Tween Bridge Solar Farm

9.8 Statement of Common Ground with Isle of Axholme & North Nottinghamshire Water Level Management Board

Document Reference: 9.8

Revision 4

Figure 2.9: Indicative Layout and Cross Section Plans
Drawing Ref: Typical Culvert Crossing

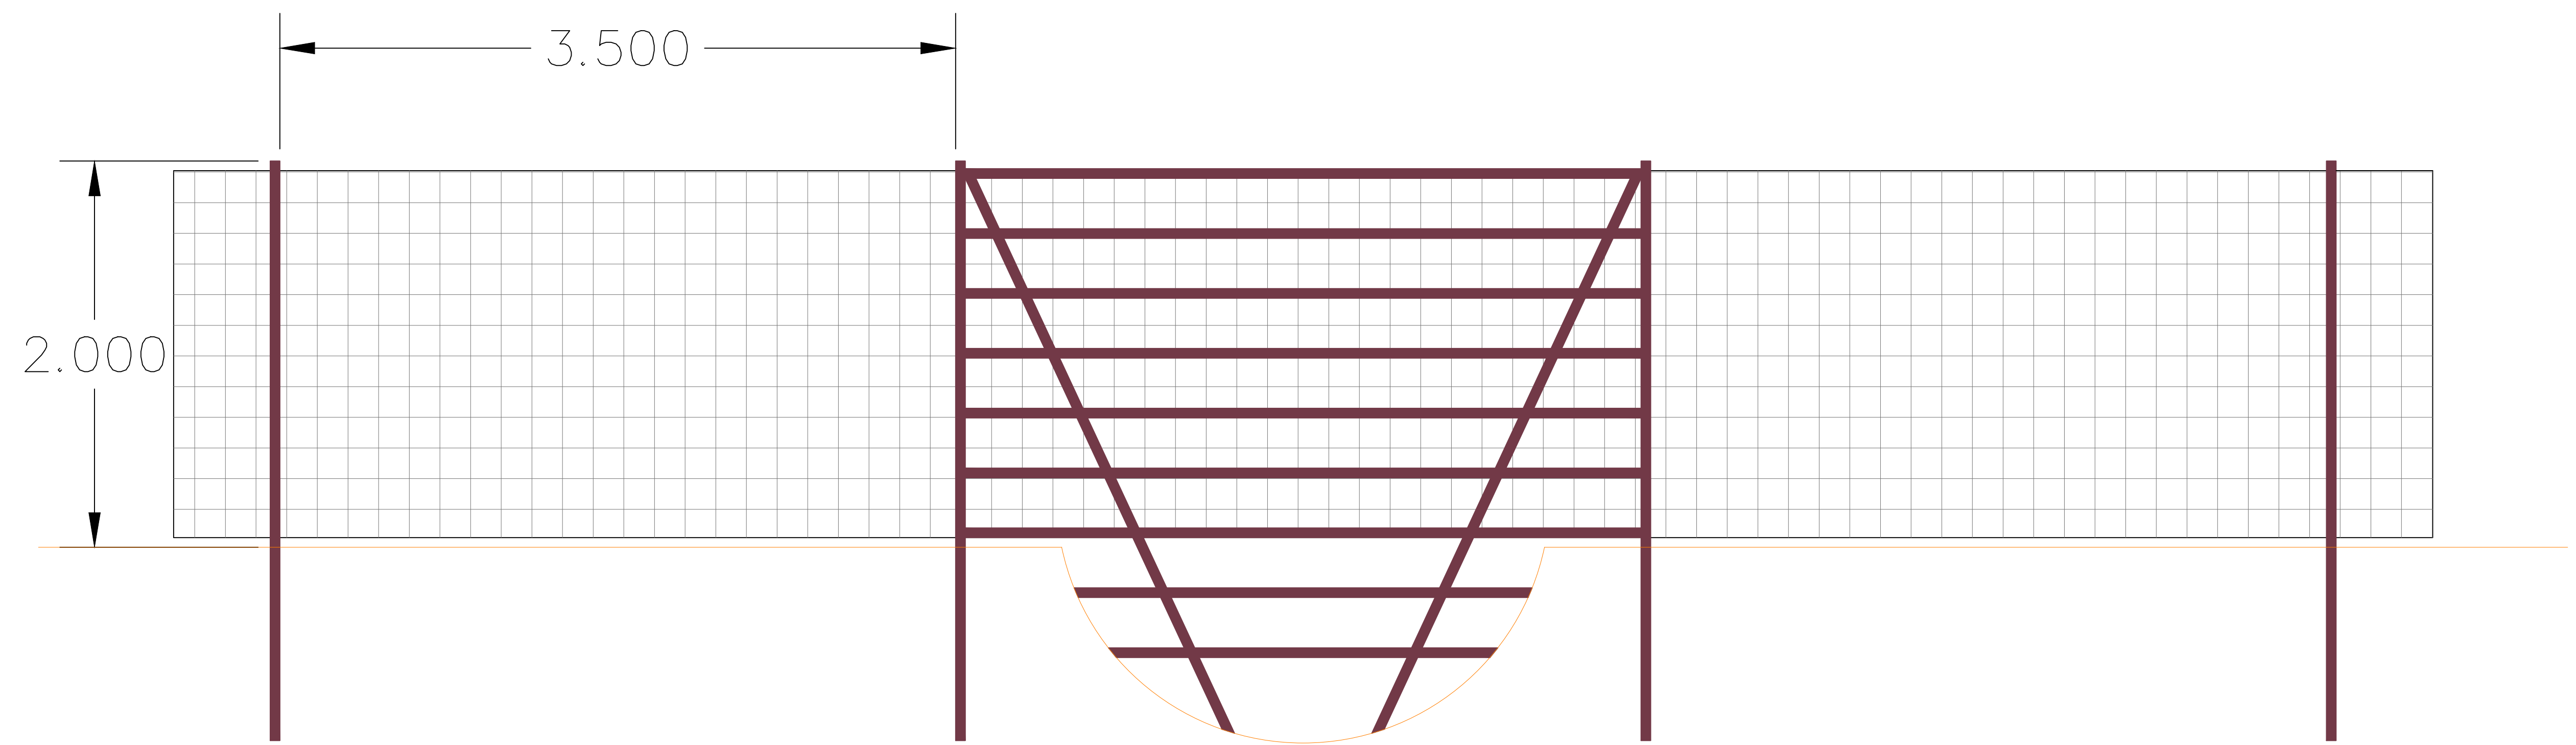
5.	Culverting/Other Works	Any culverting or other works within the bed of any riparian watercourse within the Board's district or extended area, be they temporary or permanent will also require consent.	The Applicant agrees to provide details of the culverting during the detailed design stage once the draft DCO [Document References 3.1 Revision 11] is made. Further discussions will be held with the Board. The Applicant draws attention to paragraph 20(1) and (2) of the Protective Provisions in the draft DCO [Document References 3.1 Revision 11] which provide the Board with approval power over plans for the construction of any specified works. The Applicant welcomes discussion with the Board' solicitor to discuss and agree the proposed Protective Provisions. It is noted that the Board has followed up with their Solicitor to aid the Applicant in receiving a response to their various emails requesting comments on the draft Protective Provisions. Commencing negotiations of the Protective	Agreed

Provisions with a view of reaching agreement remains the key next step. The Applicant notes that paragraph 20 of the Protective Provisions for Drainage Authorities in Part 3 of Schedule 14 to the Draft DCO [Document References 3.1 Revision 11] are agreed between the parties so welcomes confirmation from the Board that this item can now be updated to agreed.

Figure 2.9: Indicative Layout and Cross Section Plans
Drawing Ref: Typical Non-Intrusive Cable Crossing

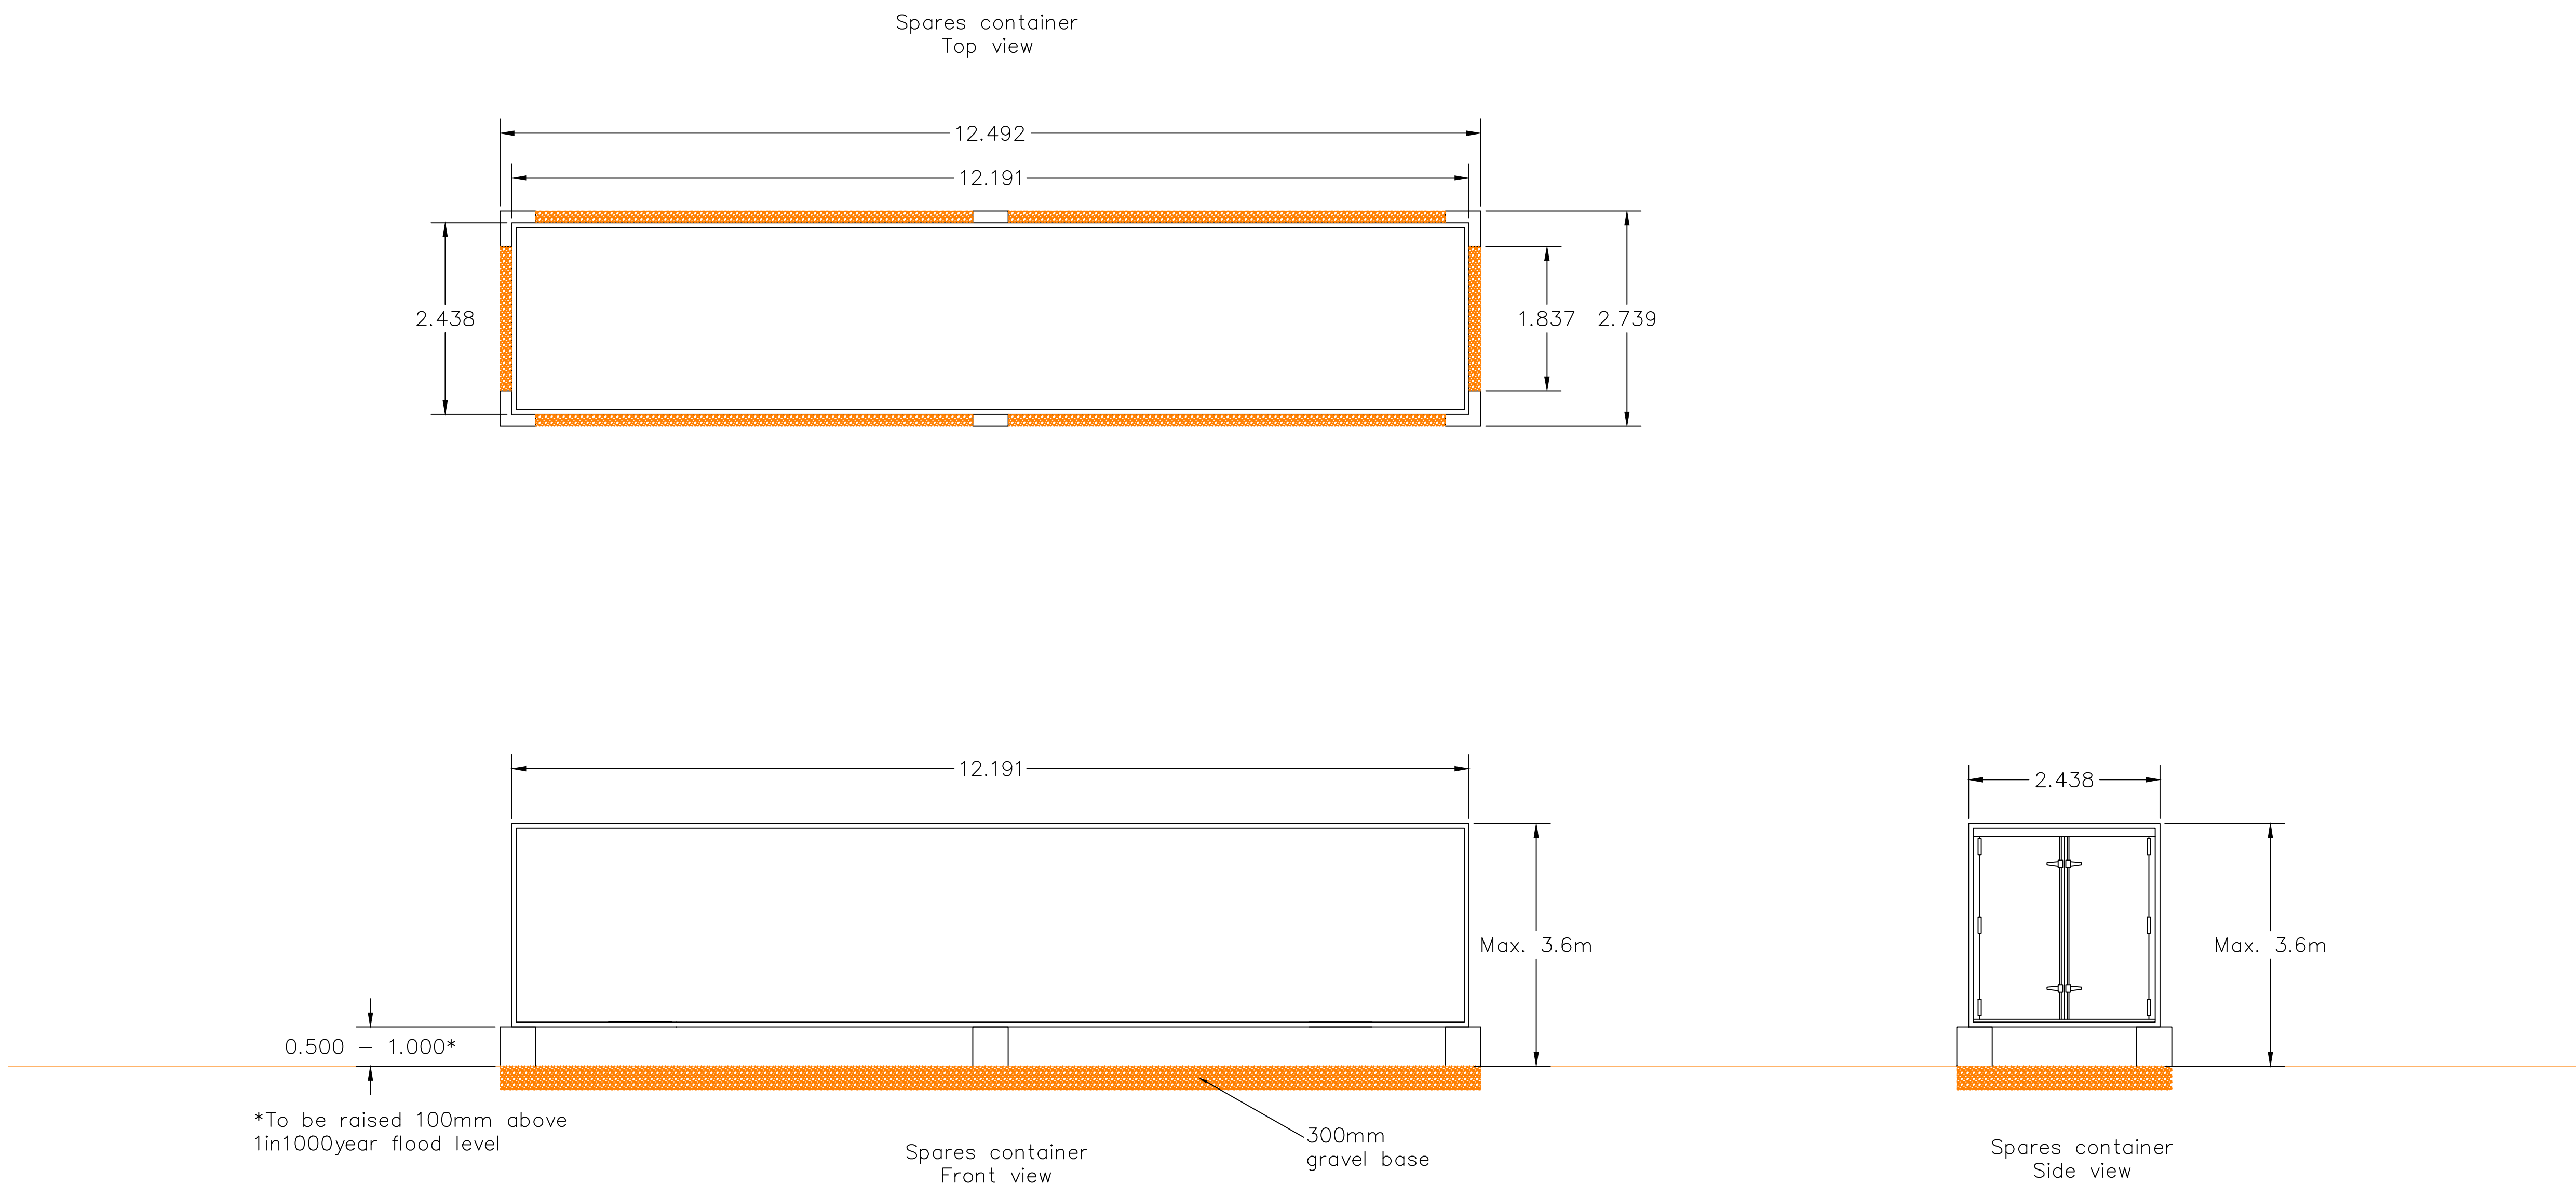
3.	Bylaw Number 17	Byelaw number 17 states that: No person shall without the previous consent of the Board – (a) place or affix or cause or permit to be placed or affixed any gas or water main or any pipe or appliance whatsoever or any electrical main or cable or wire in, under or over any watercourse or in, over or through any bank of any watercourse; (b) cut, pare, damage or remove or cause or permit to be cut, pared, damaged or removed any turf forming part of any bank of any watercourse, or dig for or remove or cause or permit to be dug for or removed any stone, gravel, clay, earth, timber or other material whatsoever forming part of any bank of any watercourse or do or cause or permit to be done anything in, to or upon such bank or any land adjoining such bank of such a nature as to cause damage to or endanger the stability of the bank;	Following a MS Teams Meeting with the IDBs on 4th June 2026, the IDBs clarified that the IDBs' comment that "the Board will require all watercourses to be crossed by means of an appropriate trenchless method at a depth no less than 2 metres PLUS the safe working distance below the hard bed level of all watercourses" applies to Board maintained watercourses only. The IDBs also detailed that where such crossing methods cannot be used, that a robust engineering justification will be required and should be documented on a watercourse-by-watercourse basis. This will be considered at detailed design stage post consent of the DCO. Paragraphs 21 and 22 of the Protective Provisions in the Draft DCO [Document References 3.1 Revision 11] for drainage authorities indicate that Applicant must construct protective works necessary to safeguard against damage from drainage works or to ensure the efficiency of flood defences. The Applicant does not consider	Agreed

(c) make or cut or cause or permit to be made or cut any excavation or any tunnel or any drain, culvert or other passage for water in, into or out of any watercourse or in or through any bank of any watercourse; (d) erect or construct or cause or permit to be erected or constructed any fence, post, pylon, wall, wharf, jetty, pier, quay, bridge, loading stage, piling, groyne, revetment or any other building or structure whatsoever in, over or across any watercourse or in or on any bank thereof; (e) place or fix or cause or permit to be placed or fixed any engine or mechanical contrivance whatsoever in, under or over any watercourse or in, over or on any bank of any watercourse in such a manner or for such length of time as to cause damage to the watercourse or banks thereof or obstruct the flow of water in, into or out of such watercourse. Provided that this Byelaw shall not apply to any temporary work executed in an emergency but a person executing any work so excepted shall, as soon as practicable, inform the Board in writing of the execution and of the circumstances in which it was executed and comply with any reasonable	non-compliance with sub-paragraphs (a) and (d) to constitute a breach. The Applicant considers that the Protective Provisions in the Draft DCO [Document References 3.1 Revision 11] for Drainage Authorities will provide the Board with adequate protection and has been continuing to engage with the Board to seek agreement on the Protective Provisions for the IDBs benefit prior to the close of the Examination. At Deadline 9, one outstanding point of drafting within the protective provisions remains between the parties. The Applicant notes that paragraphs 21 and 22 of the Protective Provisions for Drainage Authorities in Part 3 of Schedule 14 to the Draft DCO [Document References 3.1 Revision 11], which provide the Board adequate protection in respect of this item, are agreed between the parties so welcomes confirmation from the Board that this item can now be updated to agreed.

directions the Board may give with regard thereto. The Board will require all watercourses to be crossed by means of an appropriate trenchless method at a depth no less than 2 metres PLUS the safe working distance below the hard bed level of all watercourses (to ODN if EA or IDB maintained). The purpose of this requirement is to allow the IDB to maintain and have the flexibility to improve watercourses in the future due to climate change (works will include deepening & widening of watercourses). Any culverting or other works within the bed of any Board maintained watercourse be they temporary or permanent will require consent. It will usually be assumed that these structures will be temporary measures to accommodate haul roads etc.
